SUBJECT: LU/184/15/PL - Erection of 5 No. dwellings with access from Beaconsfield Road

118 & 120, Wick Street, Littlehampton, West Sussex, BN17 7JT

118 & 120 Wick Street, Littlehampton : Proposed New Houses :
Proposed Bike and Bin Stores 1: 50 scale on A4 paper

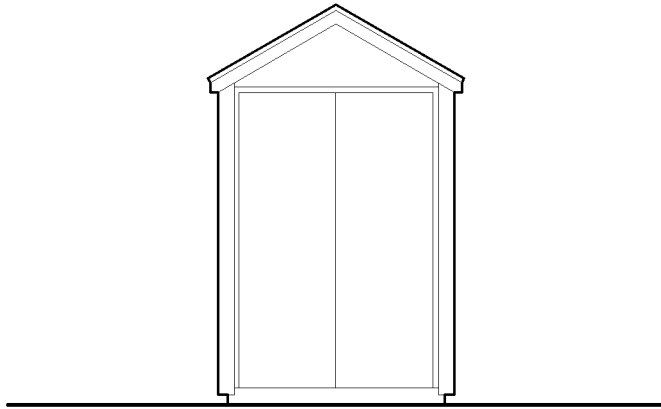
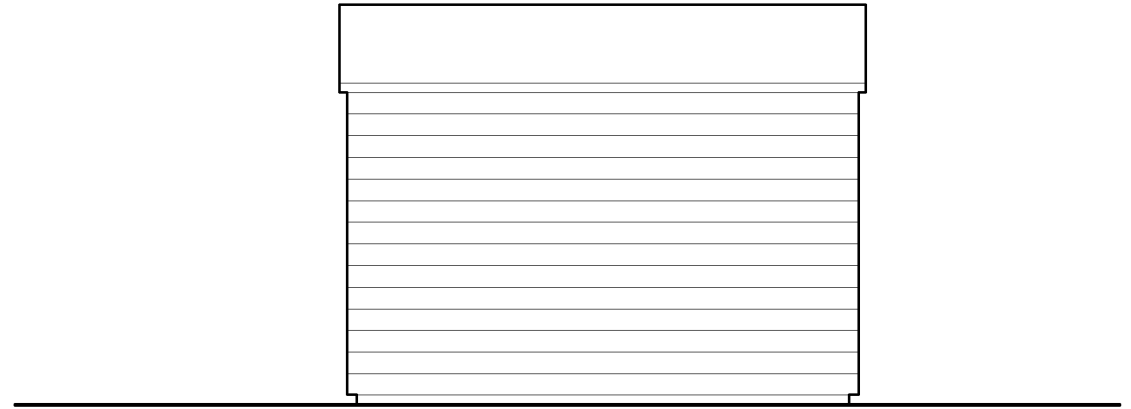
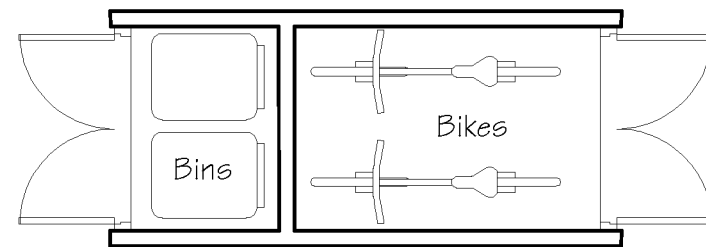
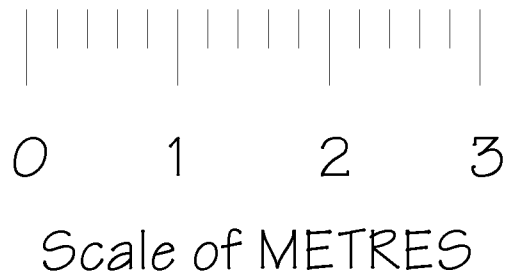
The site is situated within a sustainable location with good access to public transport links. Cycle stores are located in each garden with space for 2 bicycles per dwelling, which accords with West Sussex County Councils parking standards.

No dwelling, hereby approved, shall be not occupied until covered secure cycle parking spaces have been provided in accordance with a detailed construction plan to be submitted to and approved by the planning authority.
